# One Earth Solar Farm

**Draft Statement of Common Ground with Newark and  
Sherwood District Council**

**EN010159/APP/8.6.32**

~~October~~ November 2025

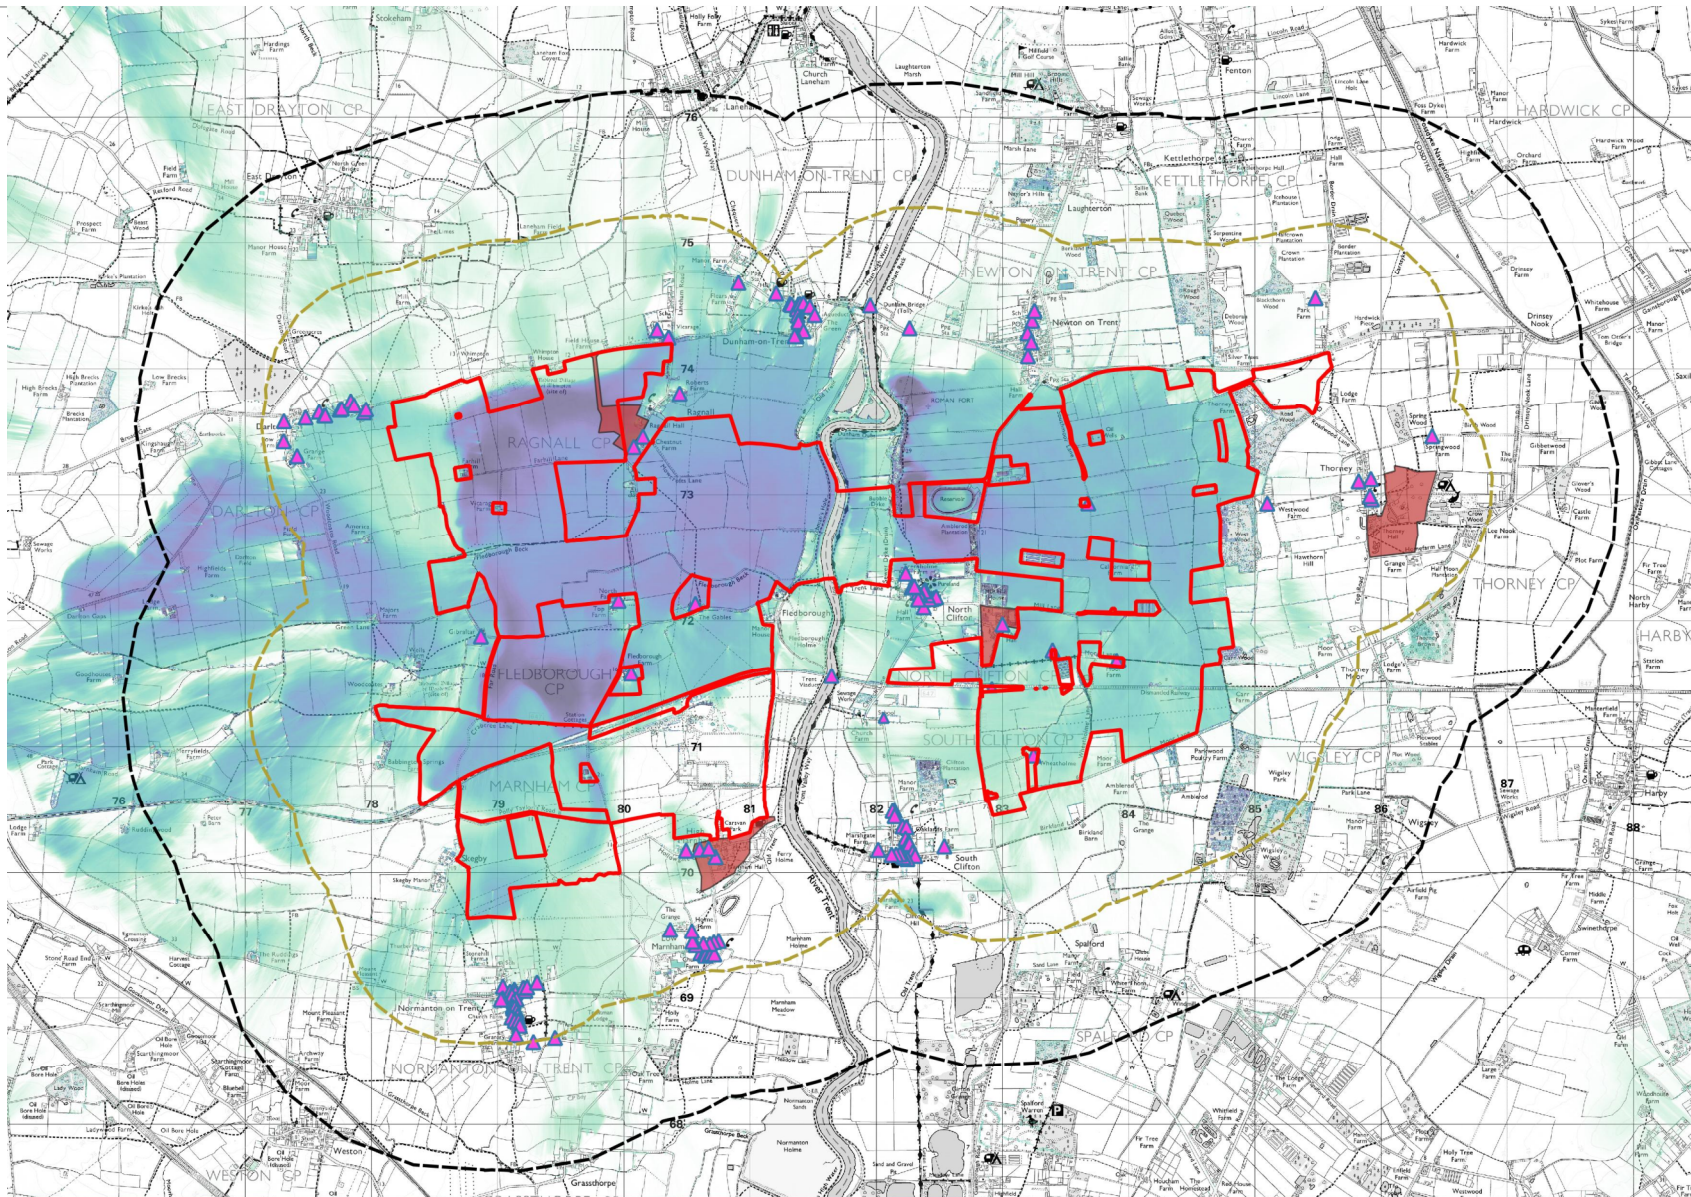
02-04	Perceived impact to Church of St George the Martyr and Church of St Helen	Further consideration required on setting of both assets and further mitigation required – specifically for the impact on Church of St George the Martyr, and Church of St Helen.	<p><u>Church of St George the Martyr</u> Effects of the Proposed Development on St George the Martyr are located within paragraphs 4.136 – 4.139, page 66 of Technical Appendix 10.3 [APP-128] and paragraphs 10.9.9 and 10.6.98.100 of ES Chapter 10 [APP-039].</p> <p><u>St Helen Church</u> This asset has been assessed in ES Chapter 10 (ref. APP-039) at paragraphs 10.6.7 and</p>	Agreed

02-06	Lychgate at Church of St George	“Impact of proposal This listing would not be as impacted as the Church of St George due to its location, but it still forms part of the wider setting.... Recommended Mitigation None would be required for this heritage asset.”	<p>The Zone of Theoretical visibility (Figure 10.3 [APP-055]) confirms no intervisibility of the Proposed Development. There would be no effect on the appreciation of the church, churchyard and lychgate</p> <p>Therefore, this asset would not change the assessed effects (or lack thereof) on the Church of St George the Martyr (Grade II*).</p> <p>Further detail can be found in the Applicant’s Response to Relevant Representations [ REP1-075]</p>	Agreed
02-07	Fledborough Viaduct	The impact of solar panels either side would be detrimental to the wider setting of the viaduct.	<p>No solar arrays are to be located on either side of the viaduct as the land is not included within the Order Limits. It is unclear which northern small parcel is recommended for removal; to clarify the nearest Order Limit north of the Site is at c.660m.</p> <p>As noted within paragraphs 10.6.68 – 10.6.71 of ES Chapter 10 [APP-039], the industrial historic interest of the asset is not reliant on views of a particular character of the landscape to understand its value.</p> <p>The Proposed Development would hold a negligible neutral effect and result in no change to the contribution of the wider setting to asset’s value.</p>	Agreed

02-13	Cottage at Thorney Hall (Thorney.	Suggestion to increase hedging to the south of the asset for mitigation.	Figure 10.3 [APP-055] confirms that there would be no intervisibility with the Order Limits. The Proposed Development would not affect the value (significance) of	<b>Agreed</b>

<p>10.6.126, in paragraph 4.191 of the Technical Appendix [APP-128].</p> <p>The Zone of Theoretical Visibility mapping [Figure 10.3 (APP-055)], the Proposed Development would hold no visibility.</p> <p>Further detail can be found in the Applicant's Response to Relevant Representations [REP1-075]</p>	
02-05	Ruins of Old Church in Churchyard	Recommendation of further mitigation to protect any views.	<p>This asset has been assessed in ES Chapter 10 (ref. APP-039) at paragraphs 10.6.7 and 10.6.126 and on page 85 of Appendix 10.2 (grouped with other assets in Thorney, as agreed with stakeholders – see Table 10.5 [APP-128]).</p> <p>The Zone of Theoretical Visibility, there would be no impact to the value (significance) of this asset, further mitigation is not required as no harm can feasibly exist which requires screening.</p> <p>Further detail can be found in the Applicant's Response to Relevant Representations [REP1-075]</p>	<b>Agreed</b>
